Planning Application Ref: WA/97/19/PL

Location: Mill Ball, Binsted Lane, Arundel, BN18 0UJ

Description of works: 1no. replacement dwelling

Mark Warwick
Tree Officer / Parks and Greenspace Team

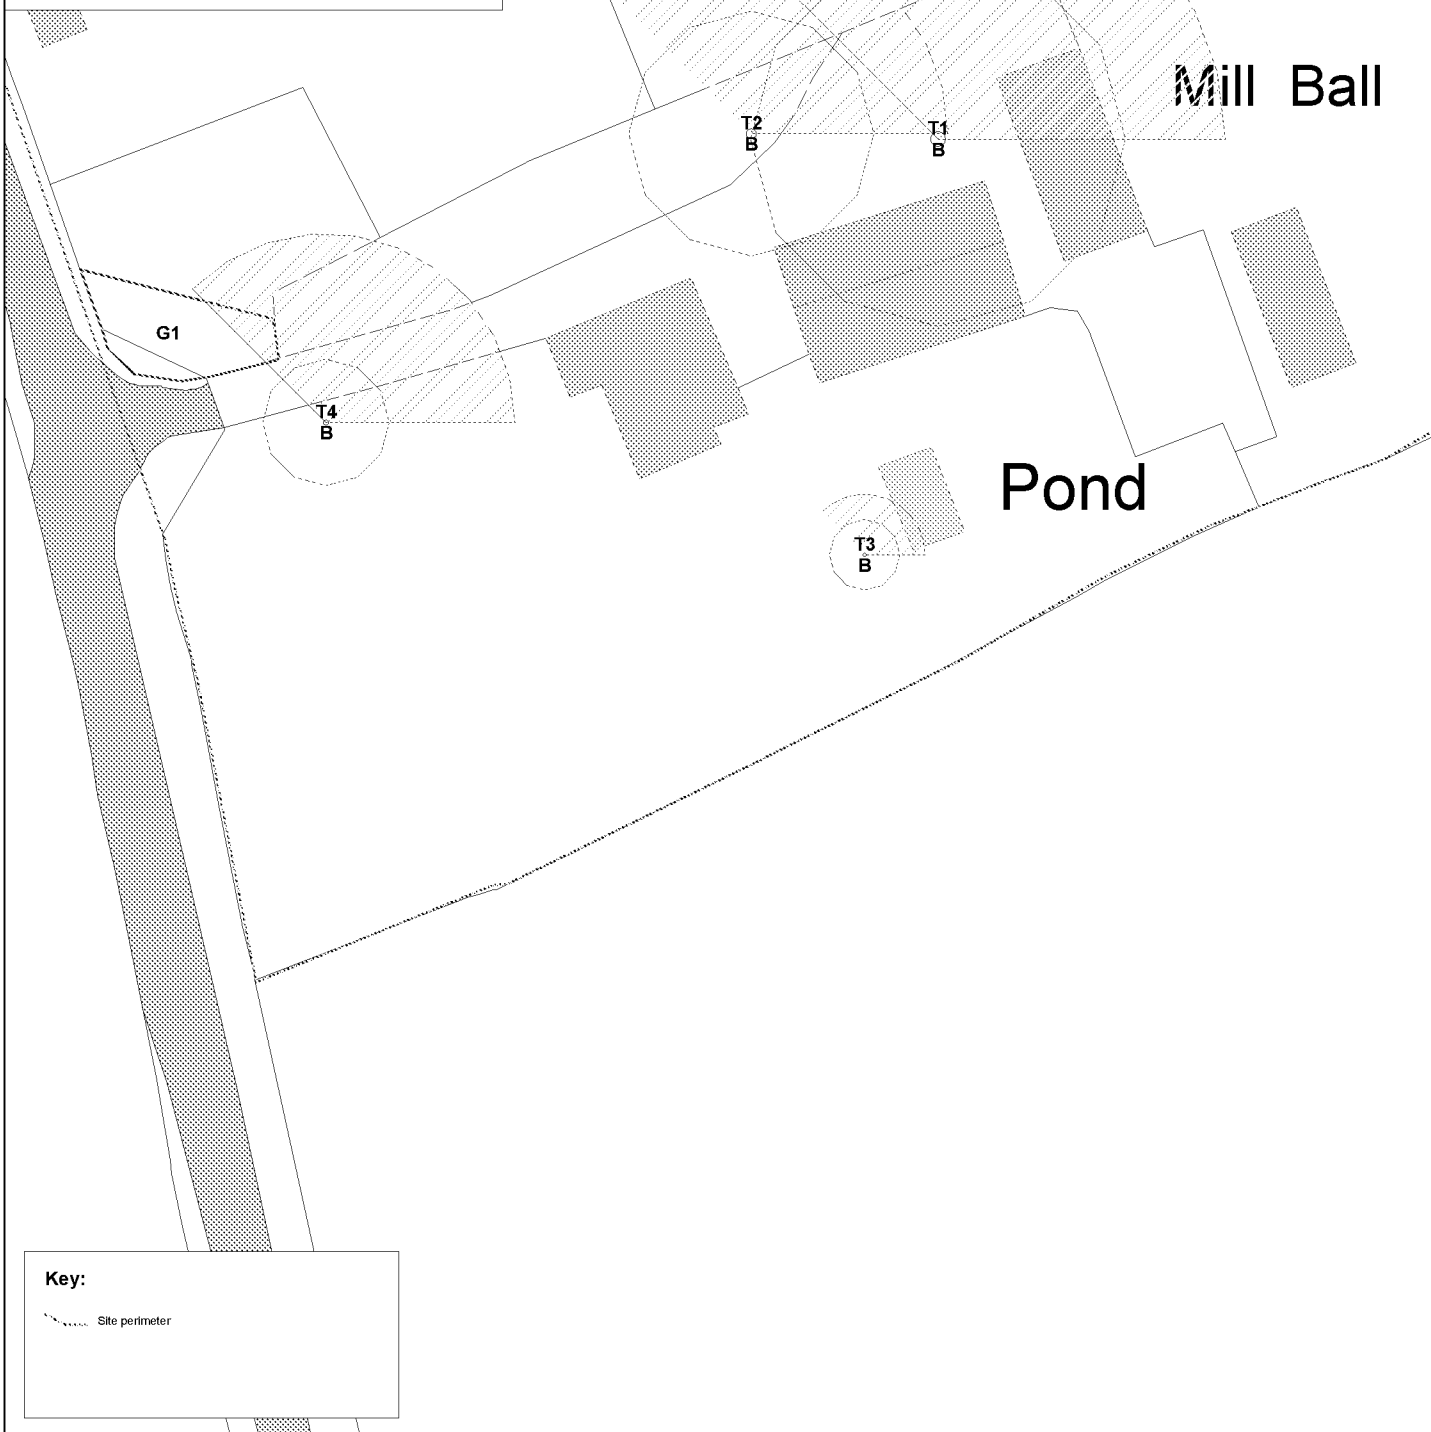
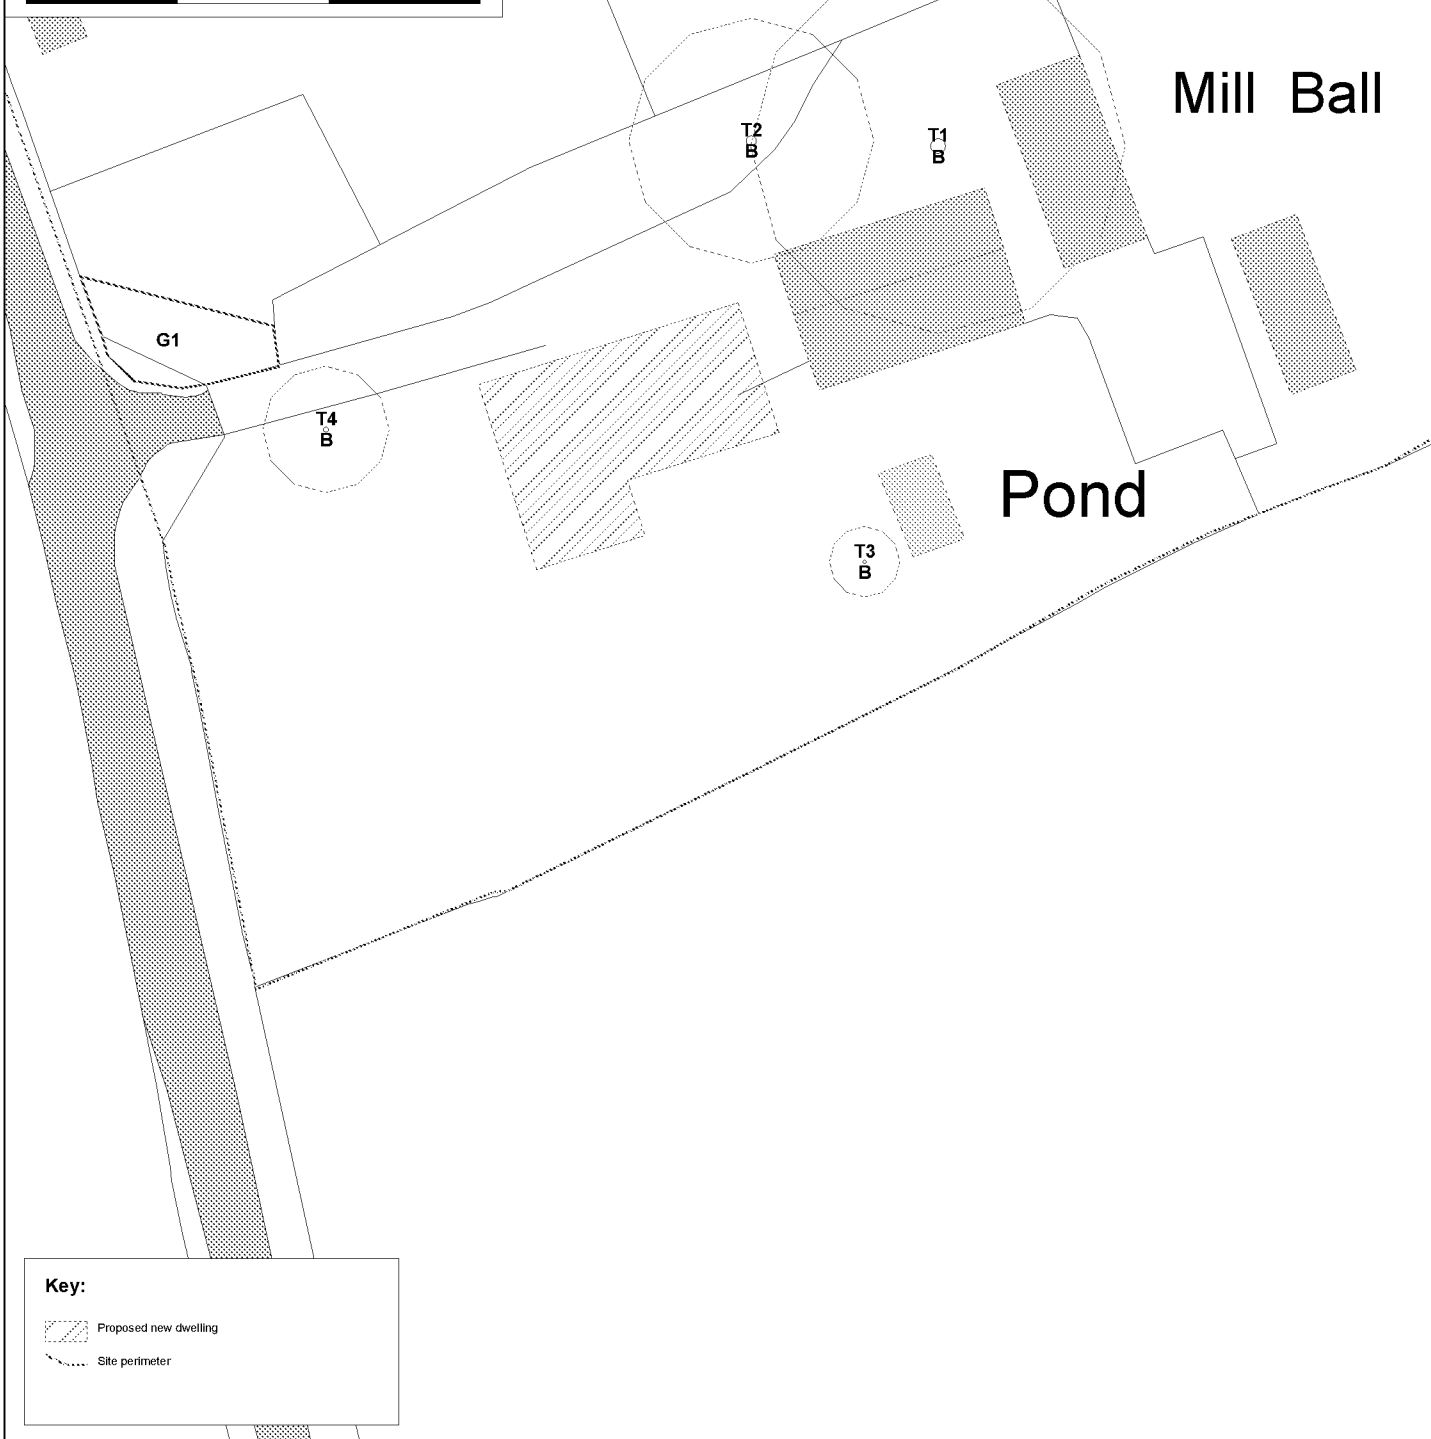
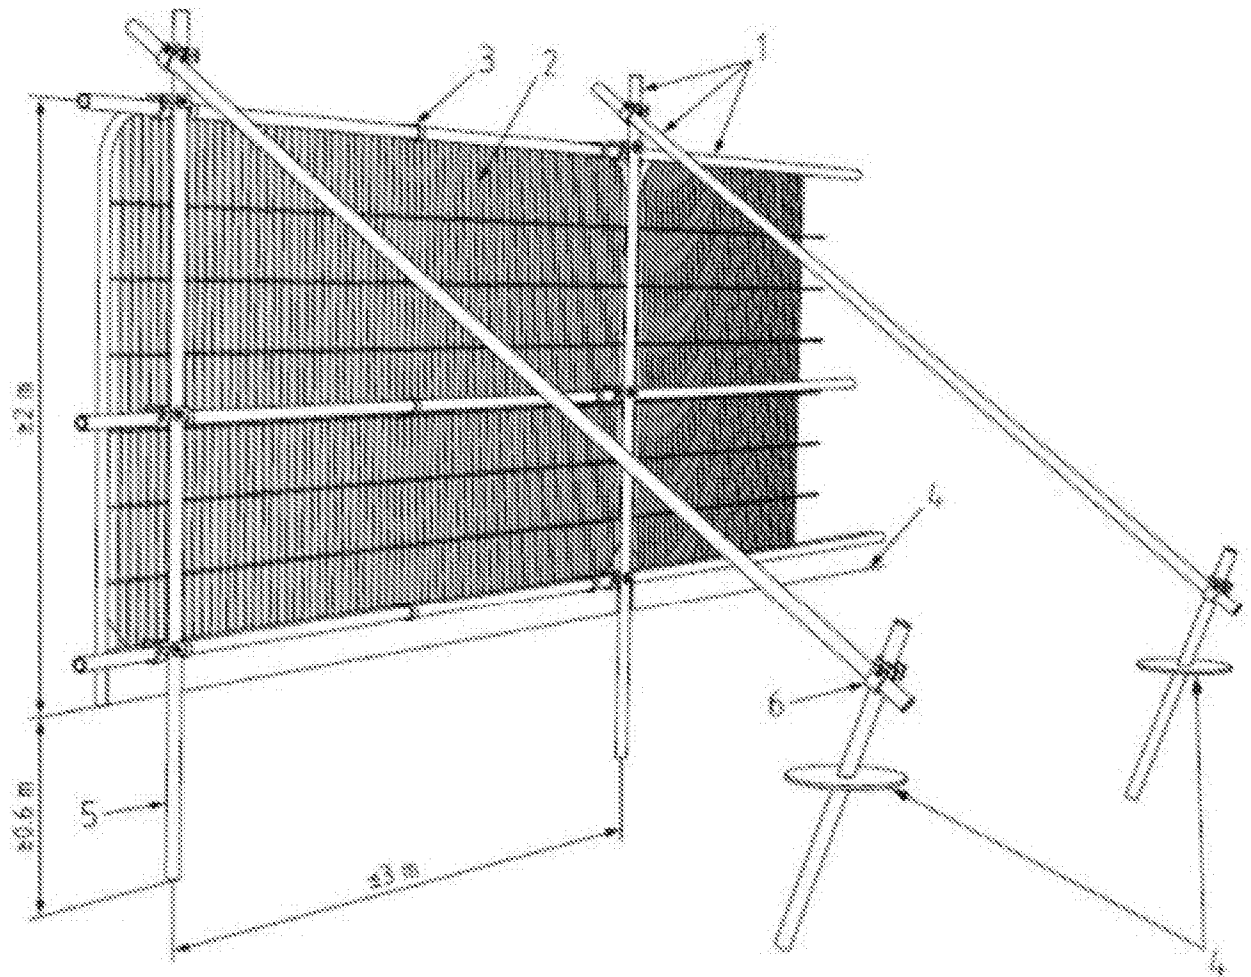
1. Before the site is occupied or any machinery is introduced to the site or demolition work or construction work or alterations to existing ground levels takes place a **PRE-COMMENCEMENT Site Meeting** is to take place between the Planning Authority's Tree Officer and the Arboricultural Expert representing the site owner(s) – at this meeting all protective fencing will be inspected to verify it is 'Fit for Purpose' as required under British Standard 5837:2012 and has been erected and positioned exactly as shown on: **Appendix 7 - Tree Protection Plan, Beechdown Arboriculture Limited, 06/12/2019.**

Part a) Any disturbance of the existing driveway and hard standing (includes all construction layers, hard wearing course and sub-base materials) which currently provides ground protection within the nominal RPA of T1-T4 incl. must be agreed in advance with the local planning authority. A Method Statement prepared by an Arboricultural Expert must be submitted that stipulates how this can be achieved without adverse impact on tree roots. Written approval and confirmation of acceptance of this Methodology must be issued before any works are commenced out on site.
